113 Newbury Condo Association Design Approval

IRON GATE

The Executive Board has reviewed the request submitted by the owners of #102, #103, #104, & #107 at 113 Newbury Condominium Association.

JOB: 113 NEWBURY STREET / ORNAMENTAL GATE FRAMES | SK-1 | JOB NO.3751

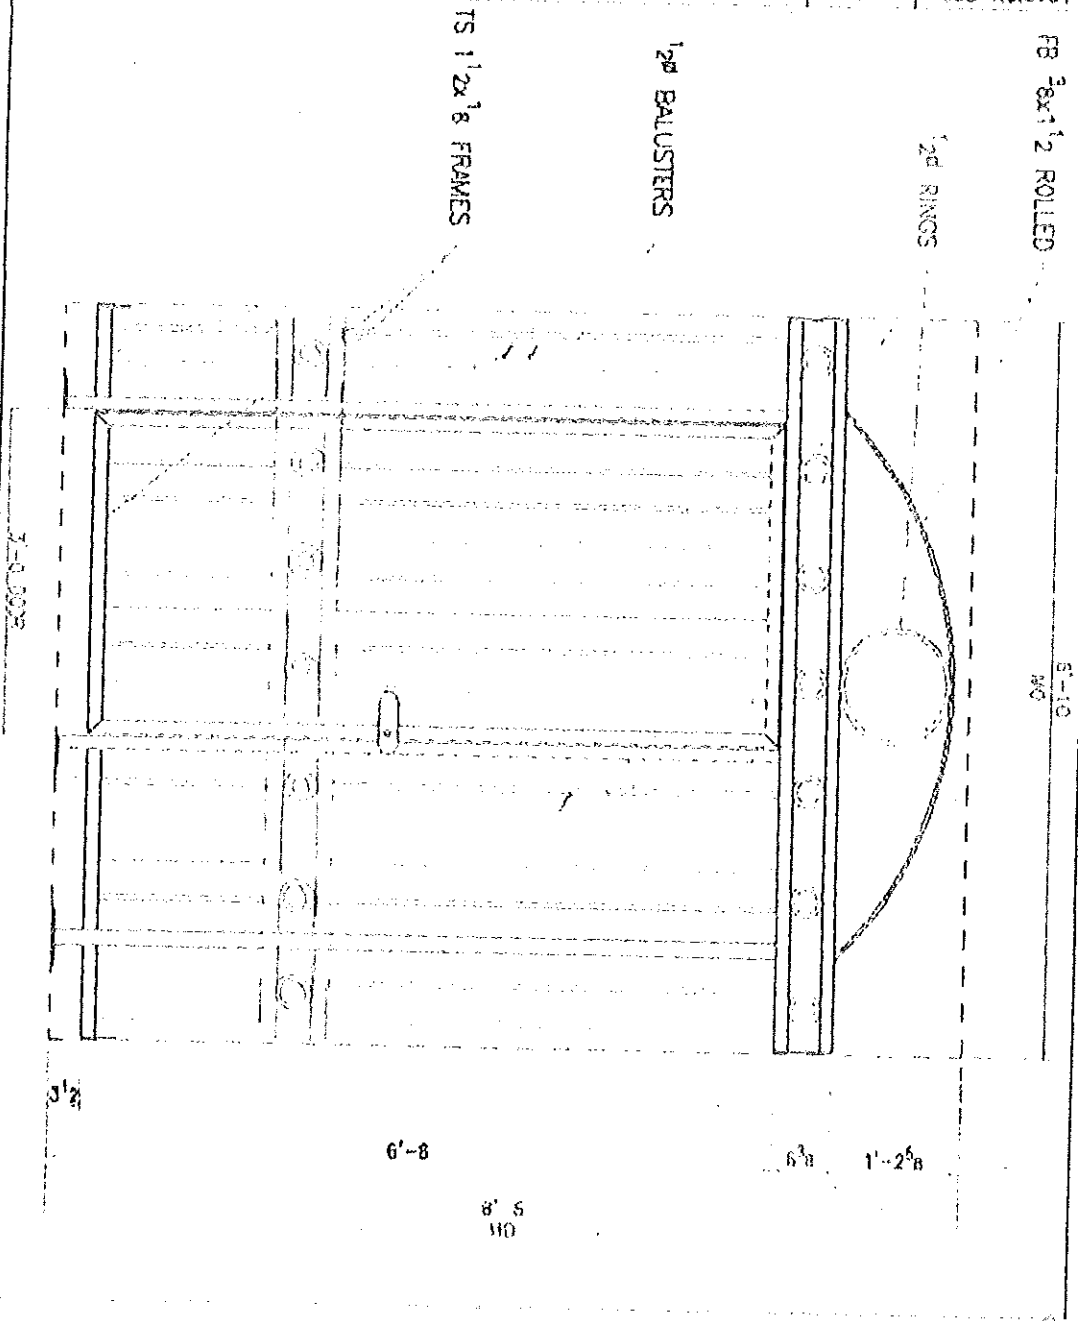
Based on the photo and sketch submitted on May 23rd, 2017 labeled Exhibit A, the board approves the installation of the iron gate installed in front of the unit entry front door facing Newbury Street with the following conditions;

1. The gate will be set in from the face of the building.
2. It is up to the individual owners to secure the necessary permits from the city.
3. The cost of installation, repair, and full replacement of the iron gate will fall solely on the owner of the unit in which the gate will be installed. The association will be responsible for the maintenance of the Iron gate.
